**Re: Lexus of Albuquerque at 8421 Pan American Freeway
Erosion and Sediment Control Plan
Engineer's Stamp Date 2/21/2023 (F17E078)**

Based upon the information provided in your submittal received 2/22/2023, the above referenced ESC Plan cannot be approved until the following comments are addressed:

CONCRETE WASHOUT

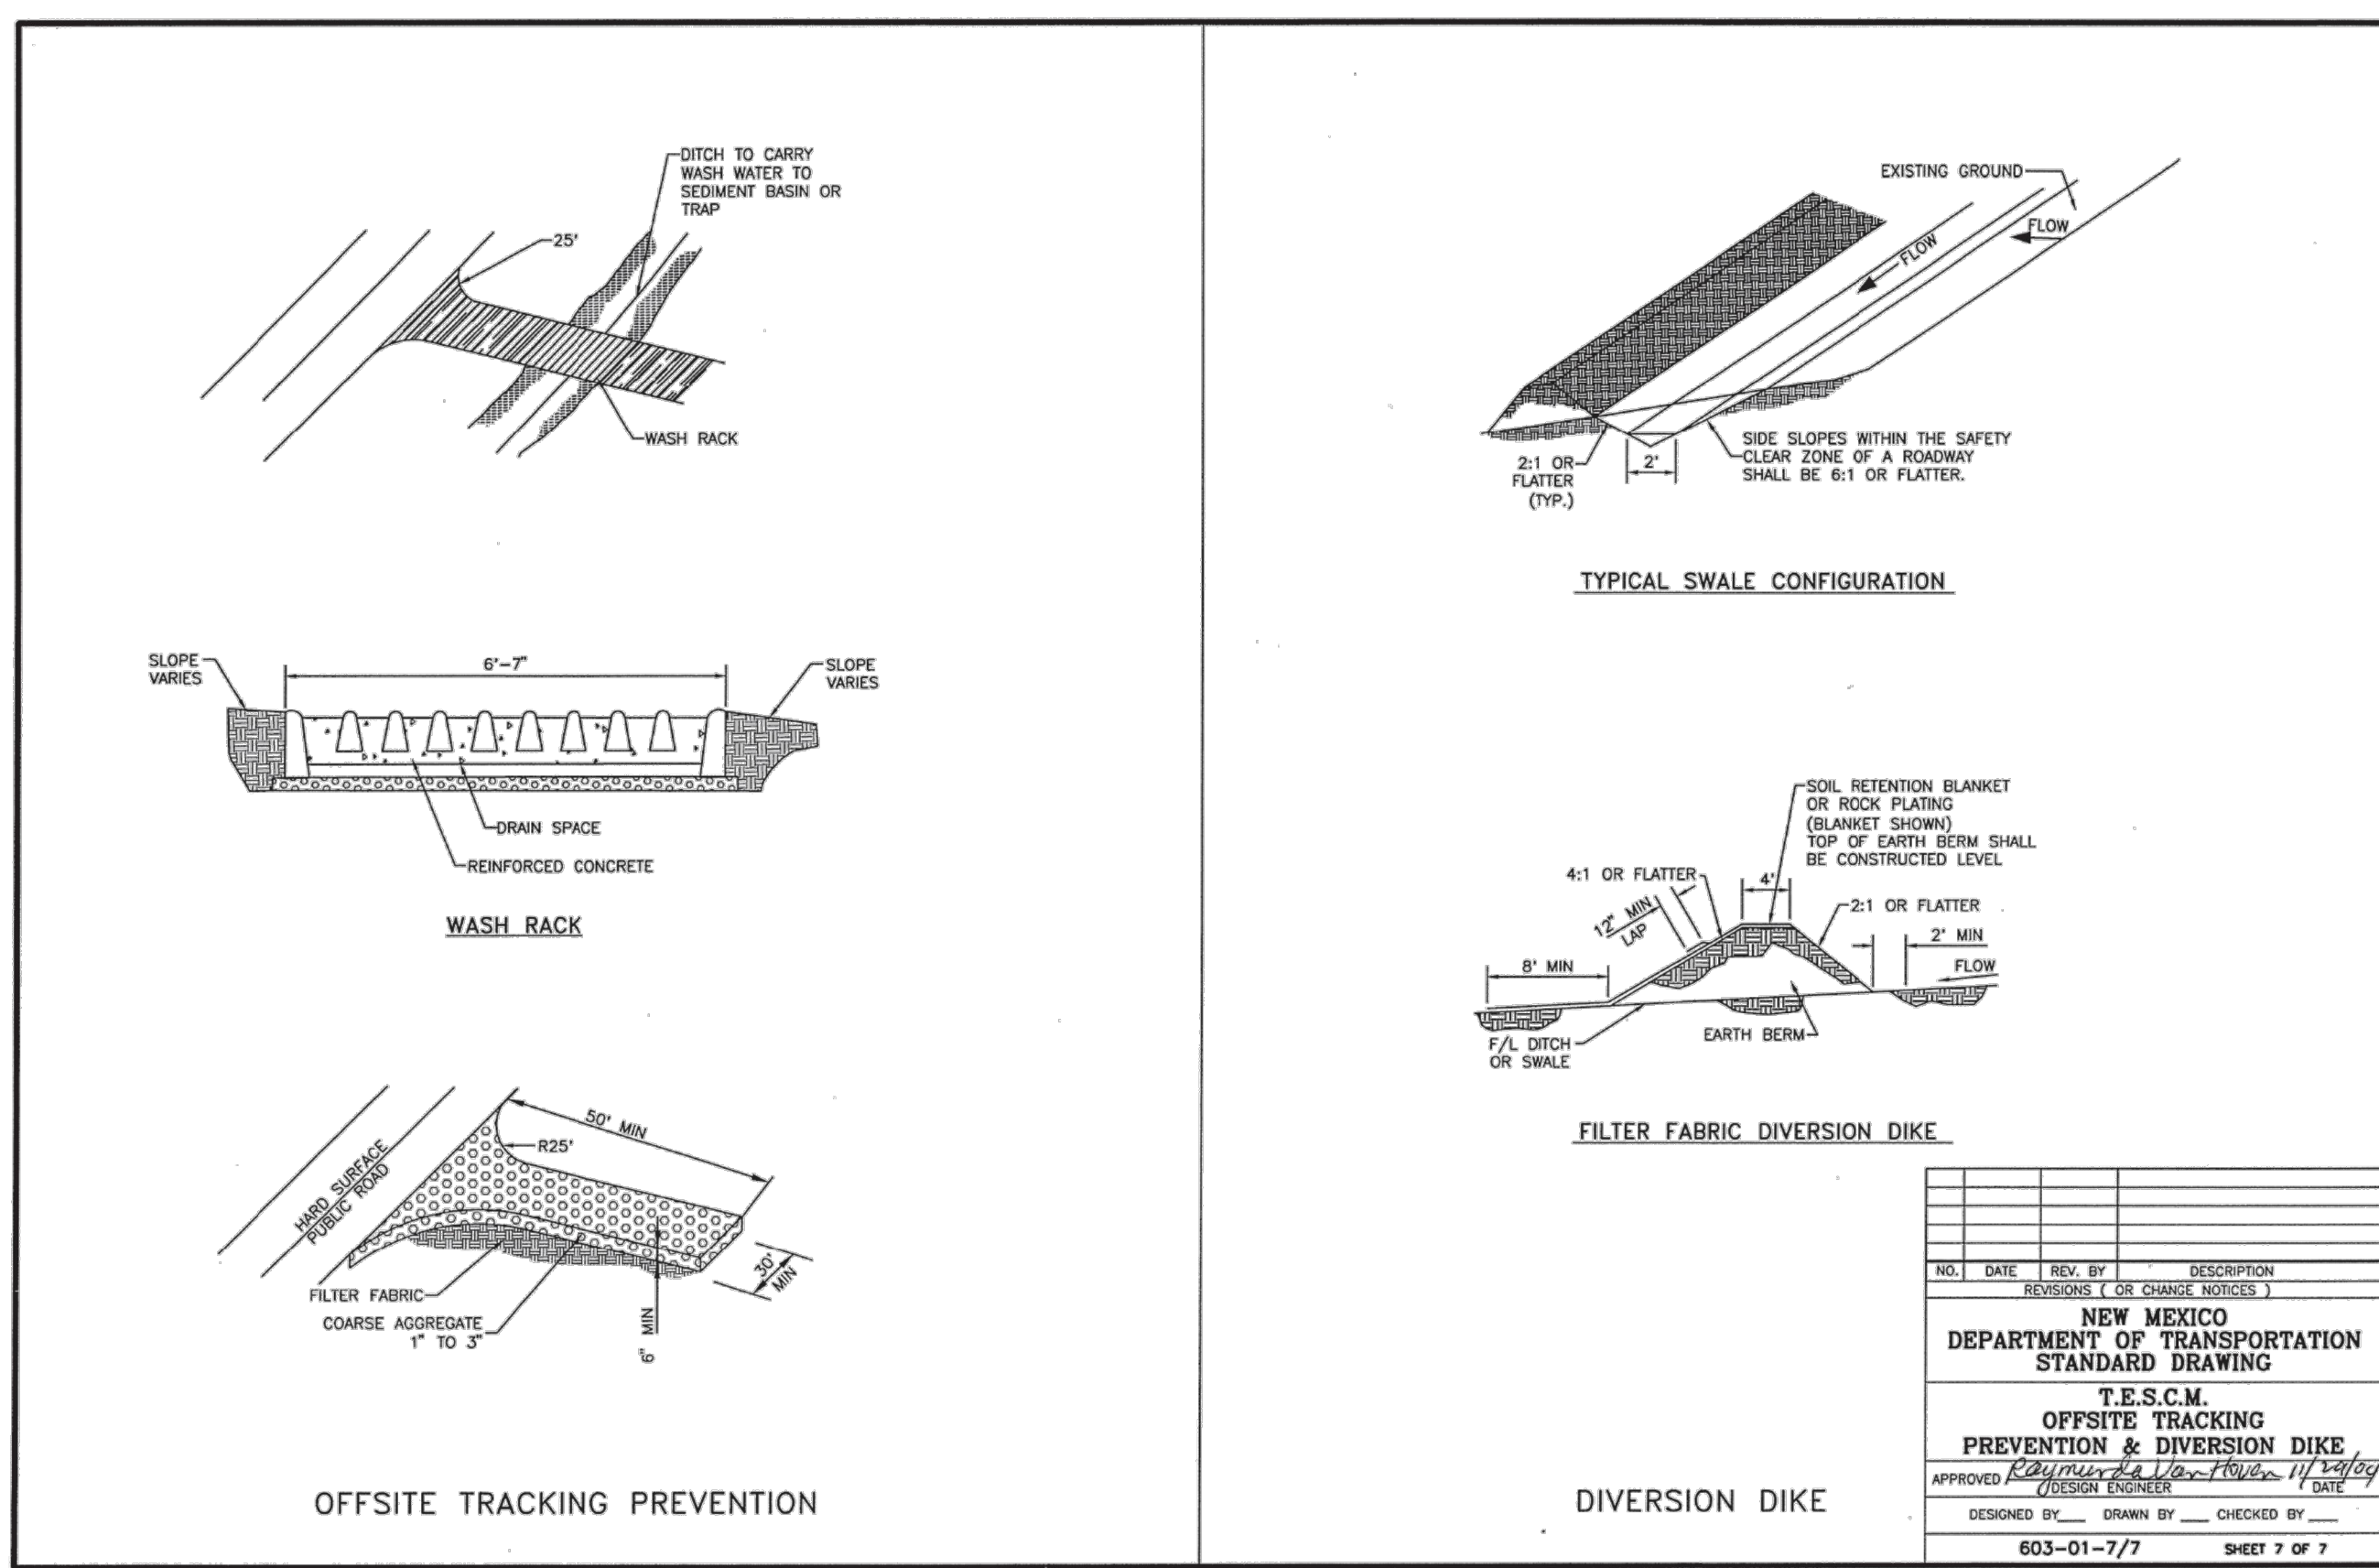
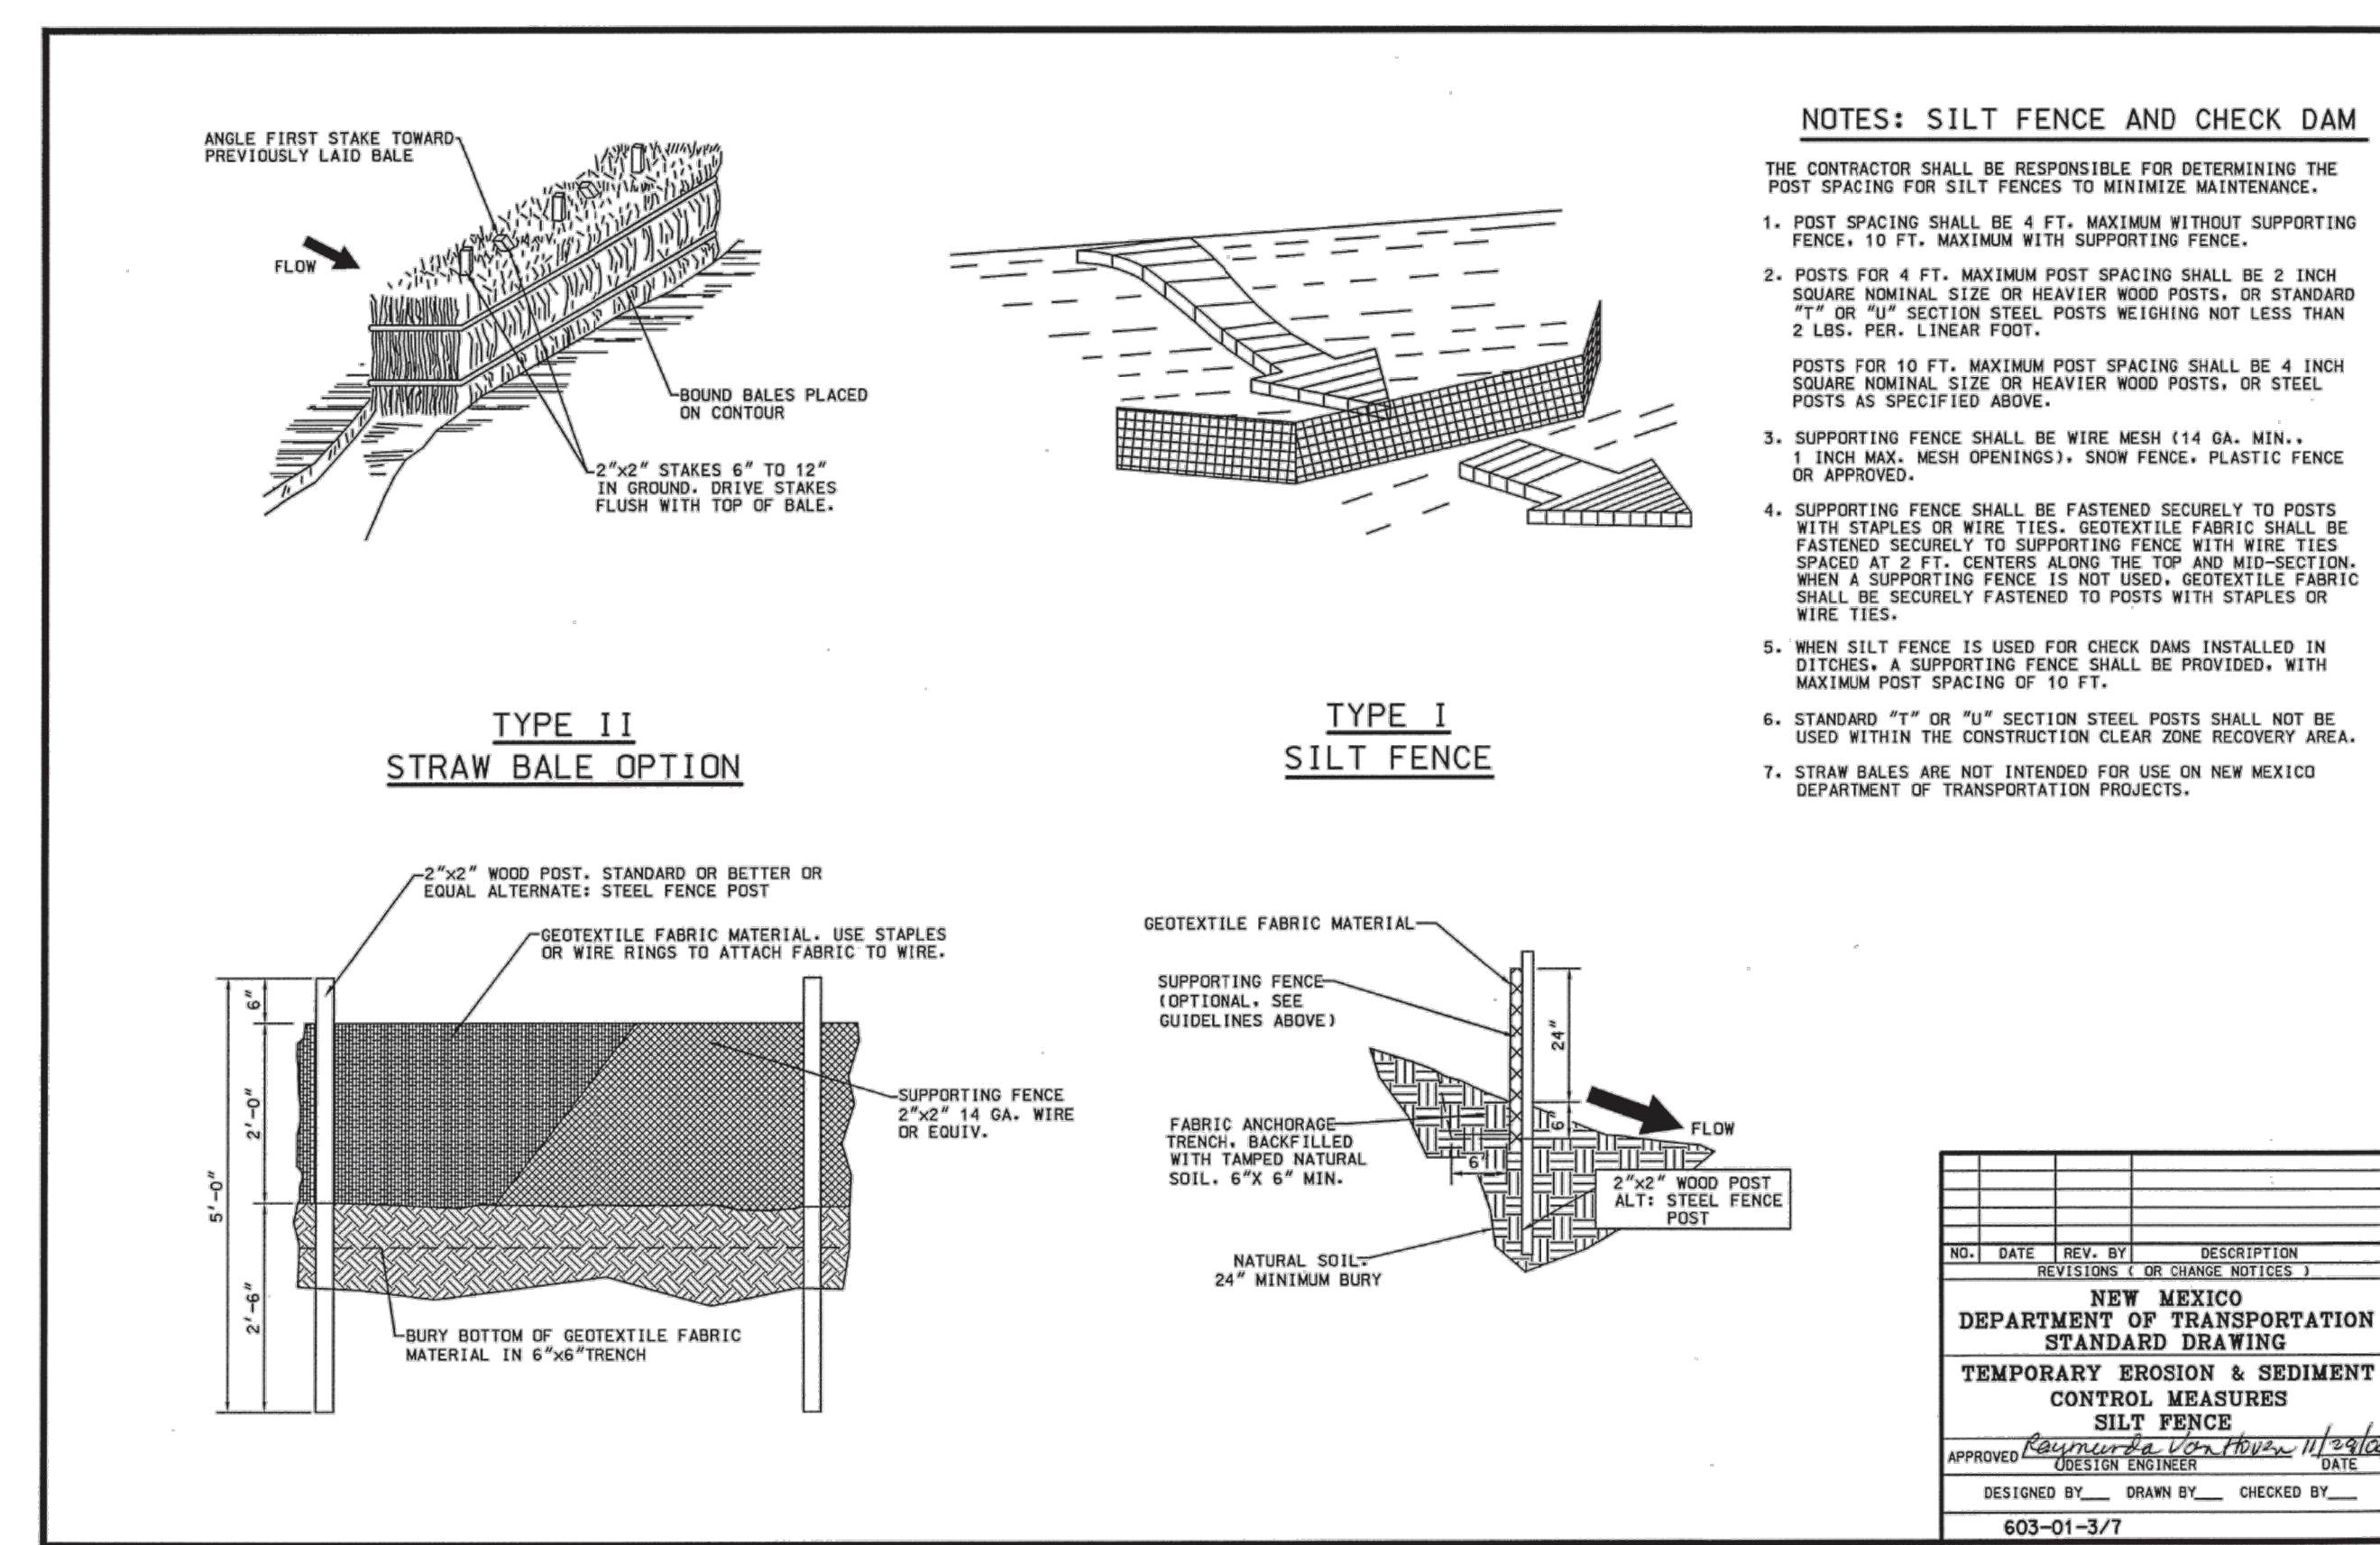
9. Erosion Control Note #10, talking about washout, should be deleted. “Direct wash water from concrete, paint, and stucco into a leak-proof container” per CGP 2.3.4. Identify the locations of the concrete washout.
